SUBJECT: Engineering Review Comment
Mountain View Electric Association Inc. (The Association)

Project Name: 440/490 Struthers Loop Lot Line Adjustment

Project Number: VR213

Description: Lot line adjustment and replat of Lots 47 and 48 in Chaparral Hills located in Township 11, Range 67, Section 36.

FINAL PLAT

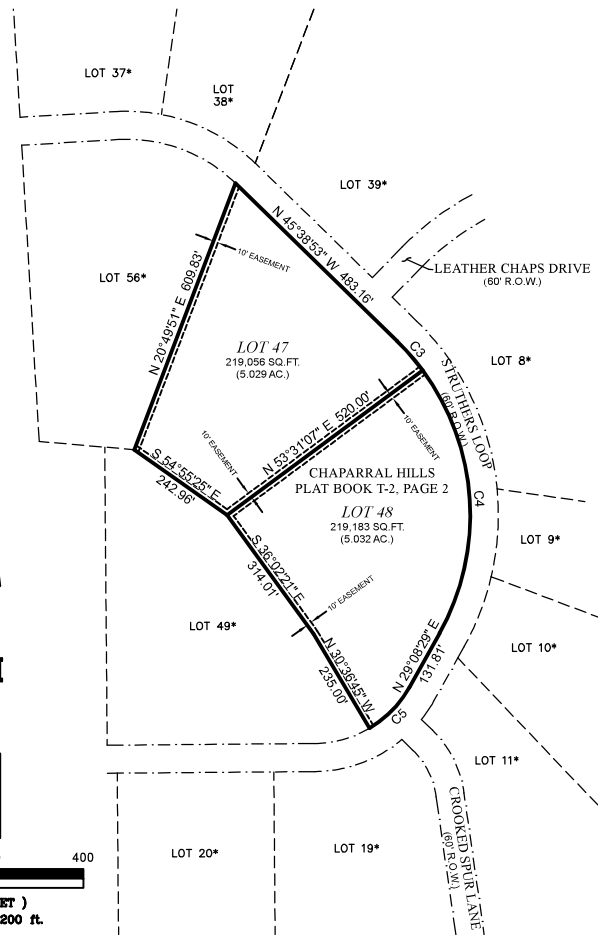
The Association requests a ten (10) foot front, side, and rear lot utility easement on the plat. The Association also requests the platting of the Association's existing facilities with easement on the plat. Additional easements may be required.

The Association has existing facilities within this parcel of land. Any removal or relocation of facilities will be at the expense of the applicant, and a review of easements will be required.
